Section 75W request to modify the approved Project Application for West Keira Development and Wollongong Central Redevelopment, Wollongong (MP06_0209 MOD 3)

The DoT generally supports the proposed modifications, but requests that the following matters are addressed and included in the final Statement of Commitments and conditions of consent:

Figure 3-2: Modified access to basement car park

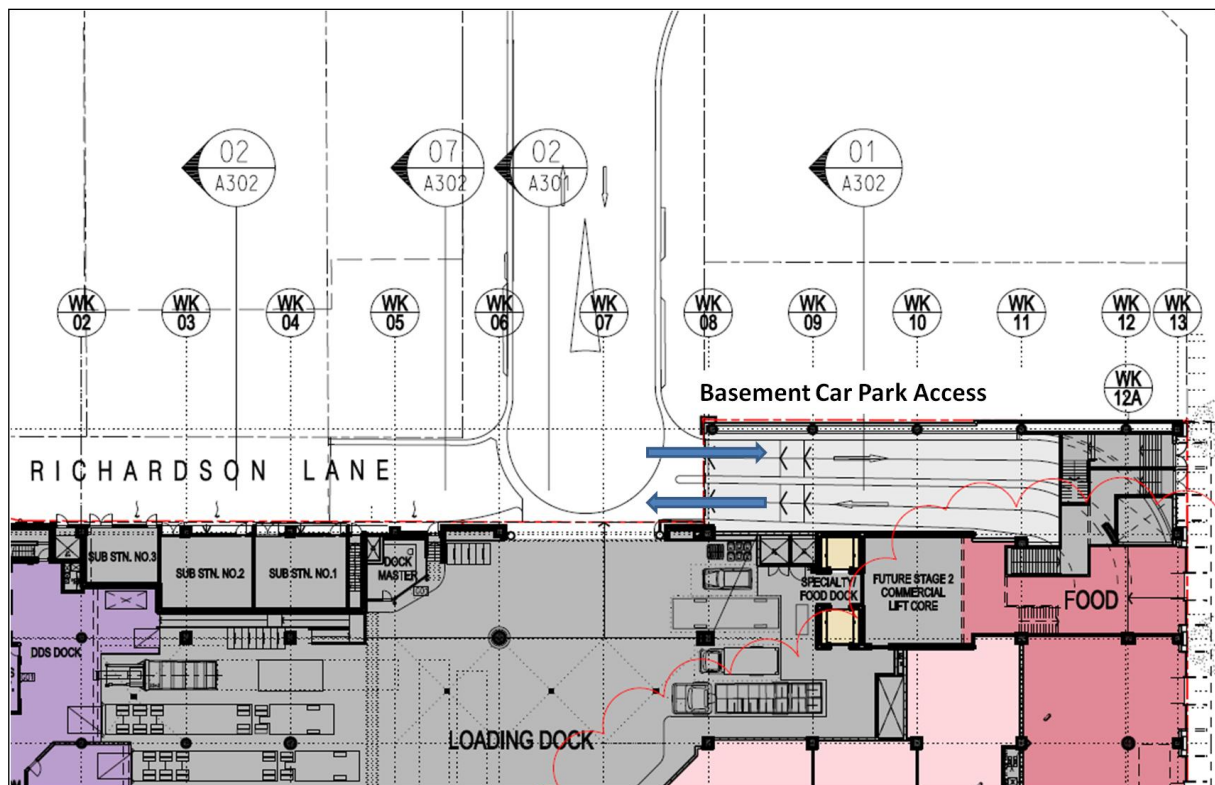
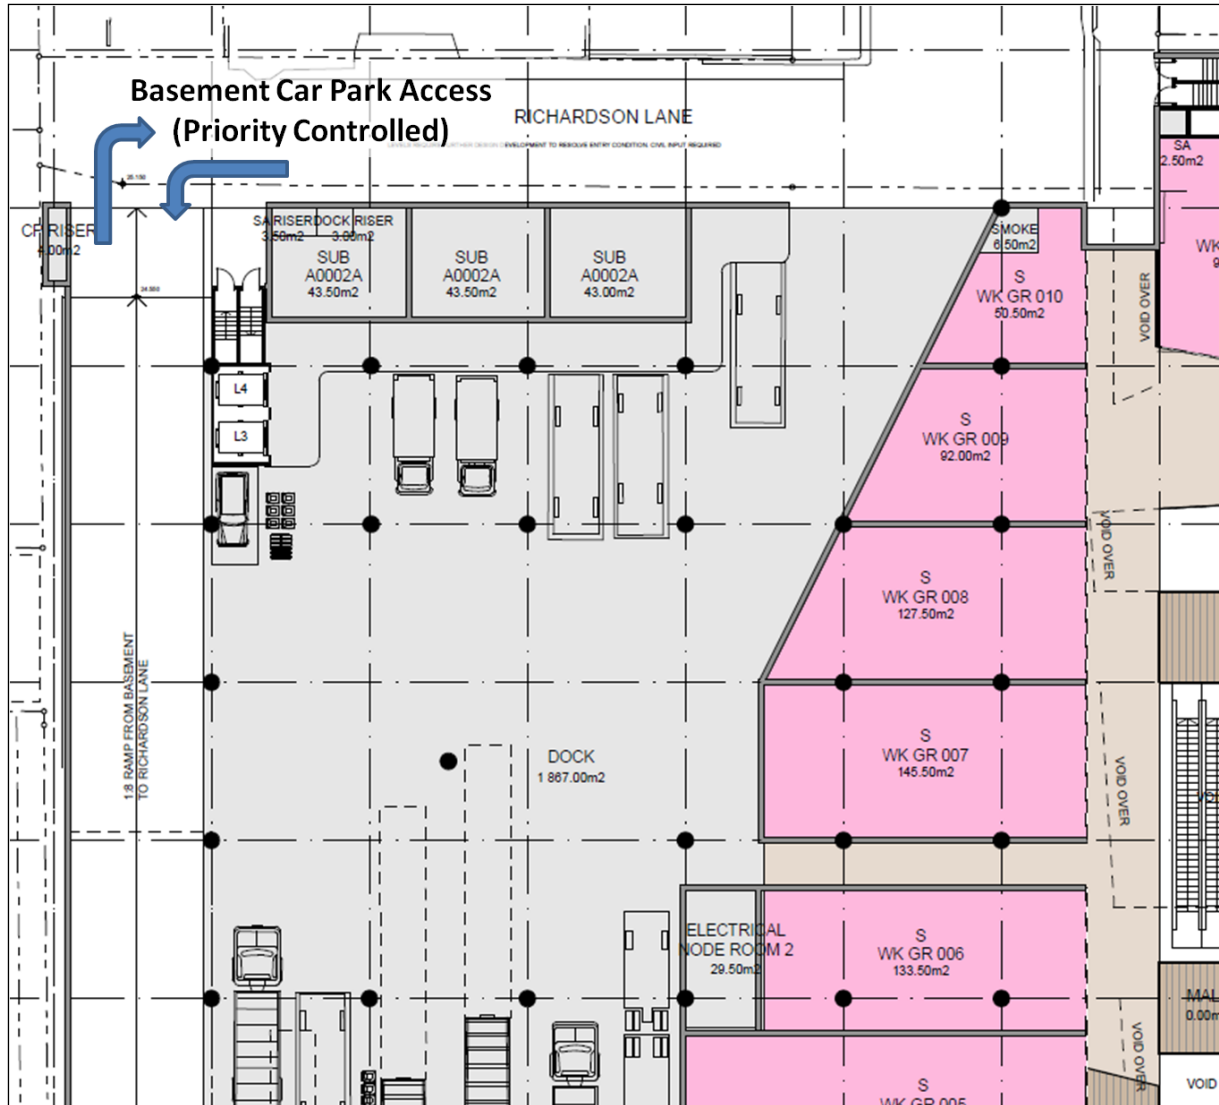
- Inclusion of car share spaces in the car park.

Figure 3-6 Location of proposed pedestrian route to Richardson Street and Market Street

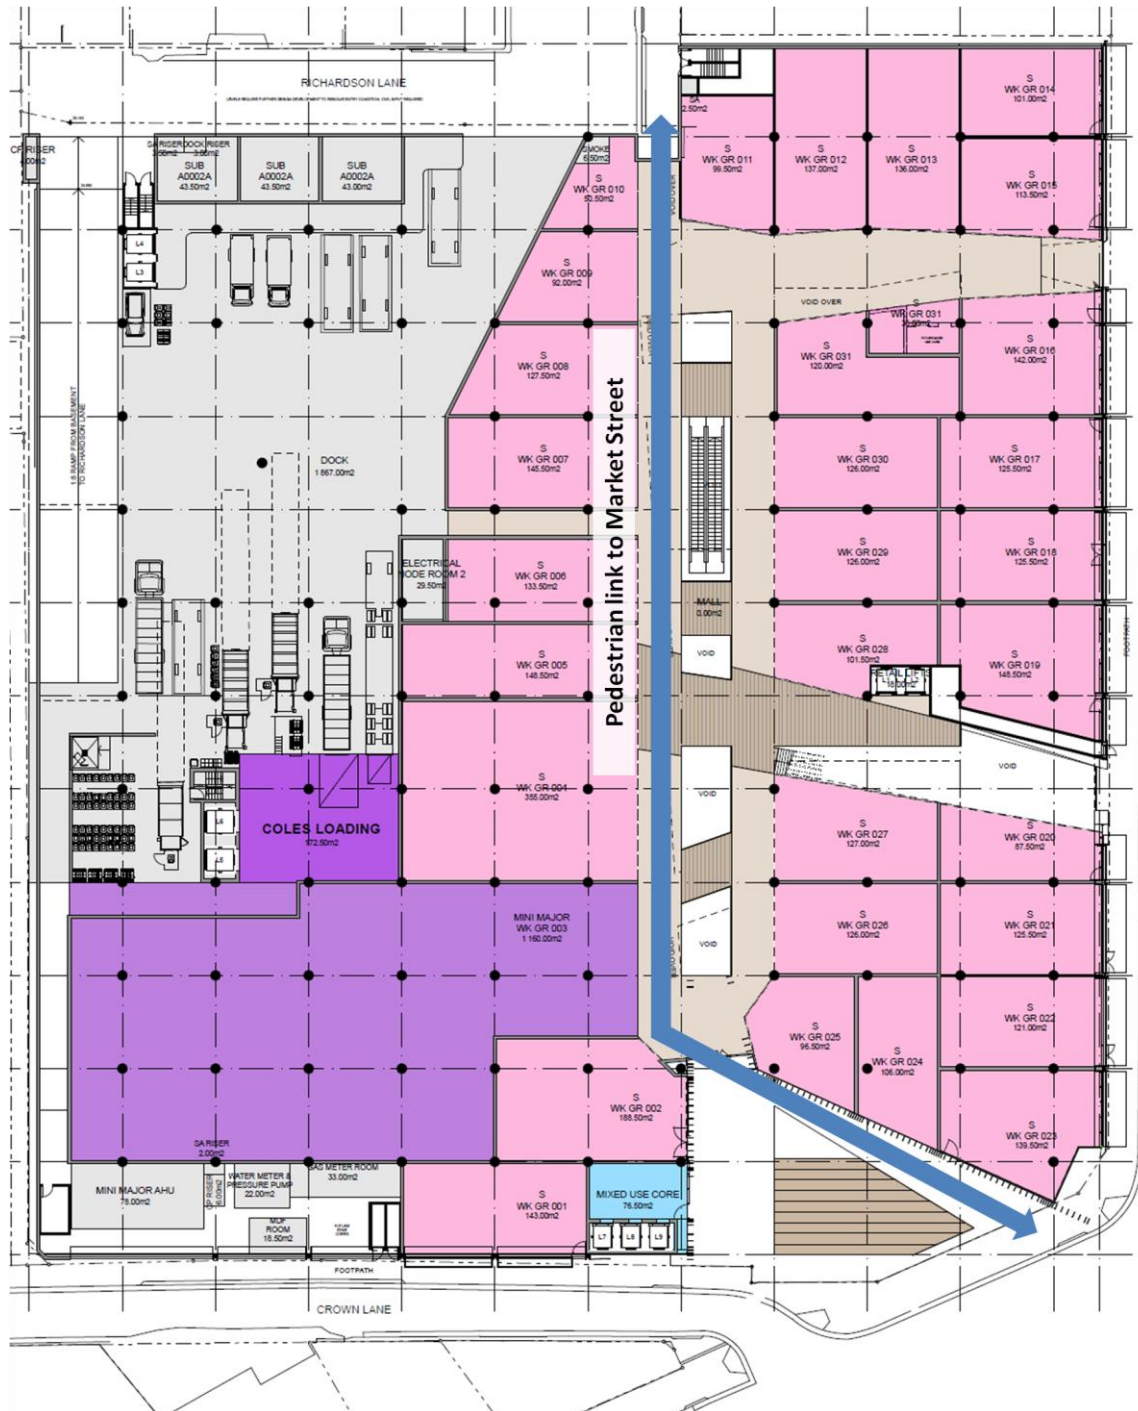
- The north-south pedestrian link through the site is to be designed as a clear visual and physical link between Richardson Street in the north and Crown Street in the south; attending particularly to its northern entry in terms of the width, aesthetics, lighting and seamless integration with the Richardson Street footpath, to make it welcoming and safe;
- Consideration is given to providing a mid-block pedestrian facility across Keira Street between Market and Crown Streets to improve convenience of accessing the ground street retailing along both sides of Keira Street, bus stops and a taxi rank;
- Bicycle parking and amenities for staff in the car park located conveniently to maximise surveillance and use;
- Customer bicycle parking provided at the main entrances to the development in accordance with the NSW Government Planning Guidelines for Walking and Cycling; and
